Project: **134-140 MARSDEN STREET,
PARRAMATTA (V BY CROWN)**

Report: **BCA ASSESSMENT REPORT**

Reference: **103823-BCA-r6**

Date: 13th August 2014

2118 Level 18

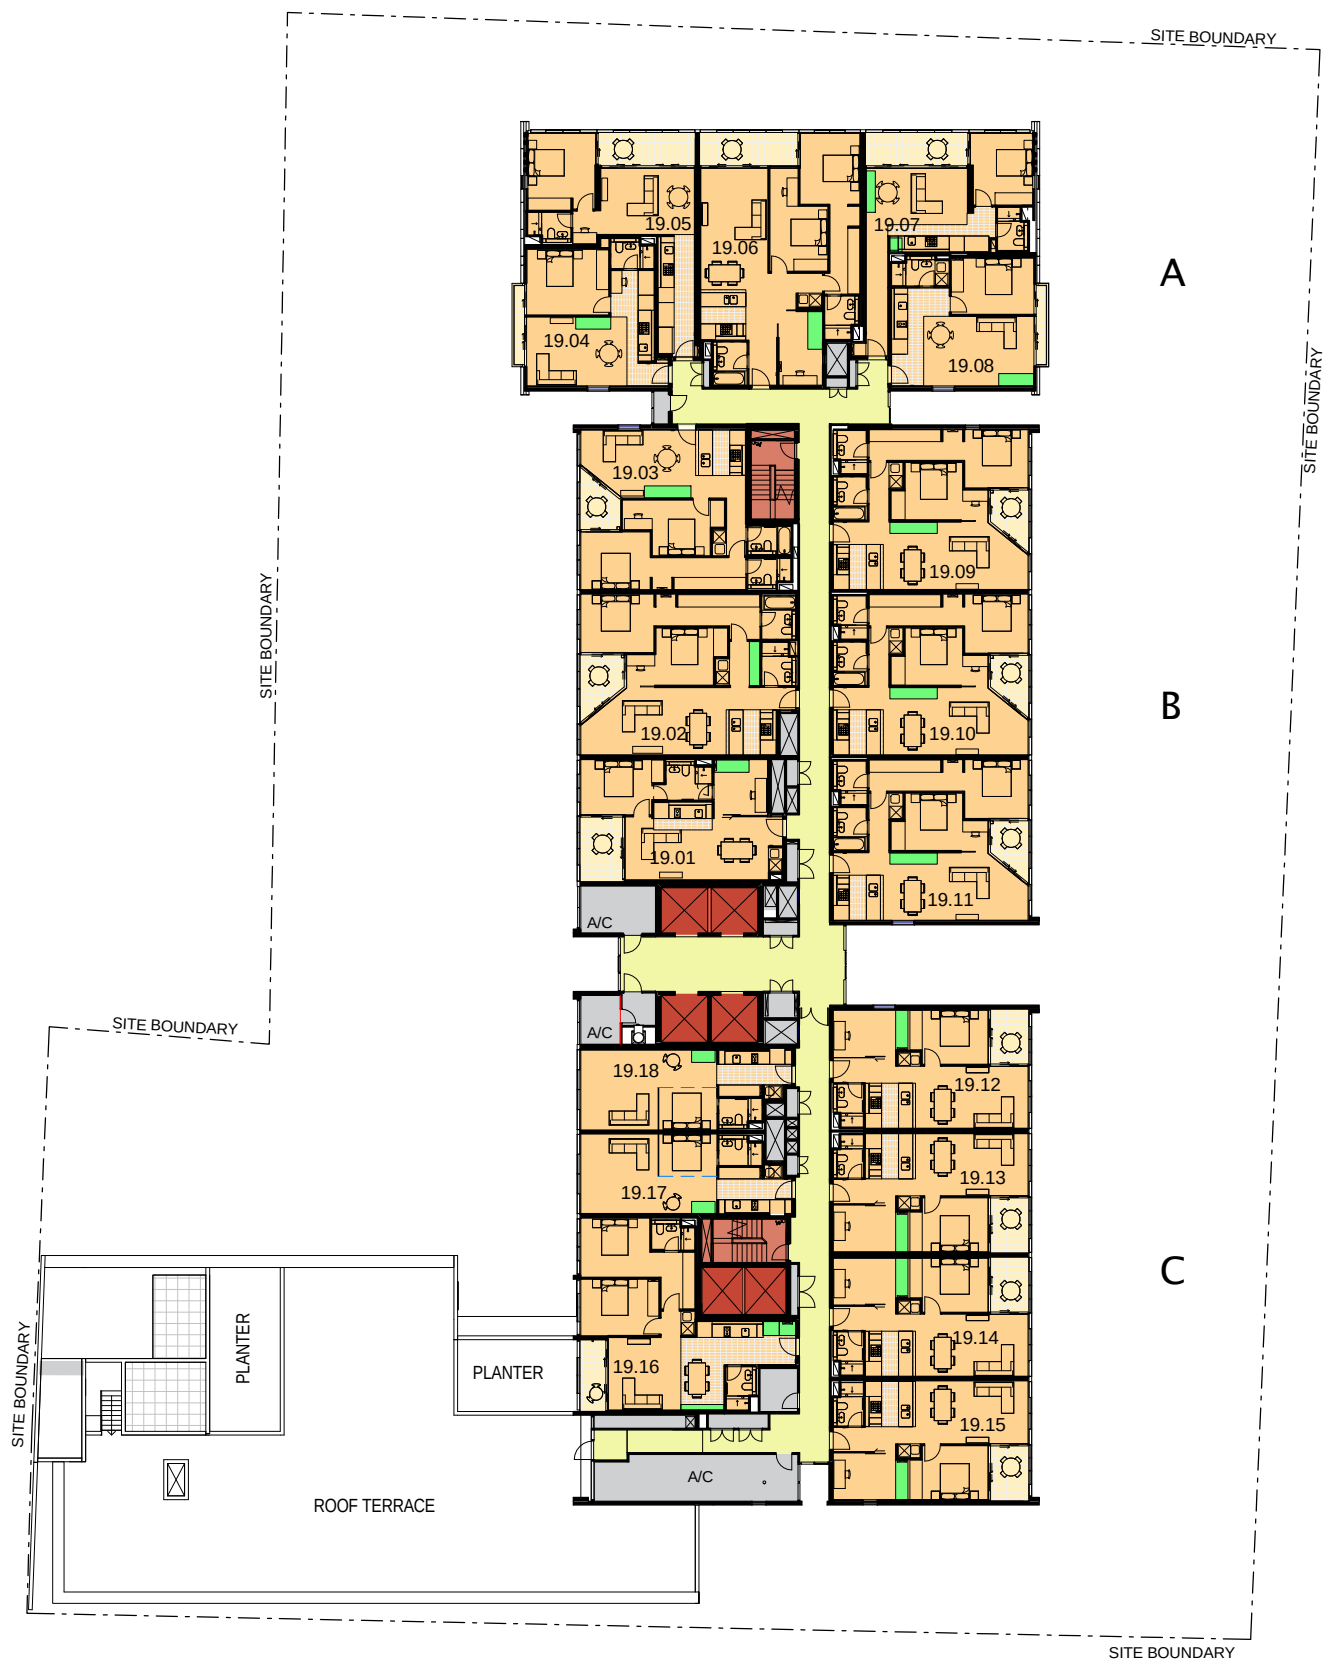
c) It is acknowledged that the doorway to Unit 28.6L at Level 28 is approx. 7m in lieu of 6m to the nearest fire stair, as shown below.

It is apparent that the swinging door on Level 18 below separates the residential apartments from the apartments in the same vicinity. Similarly, the doorway between the Bar and the residential part of Level 26 adjacent is a door on the path of travel to an exit from both sides of the door. It has been confirmed that the latching mechanism to these doors will strictly comply with this clause in the following instances.

Level 18
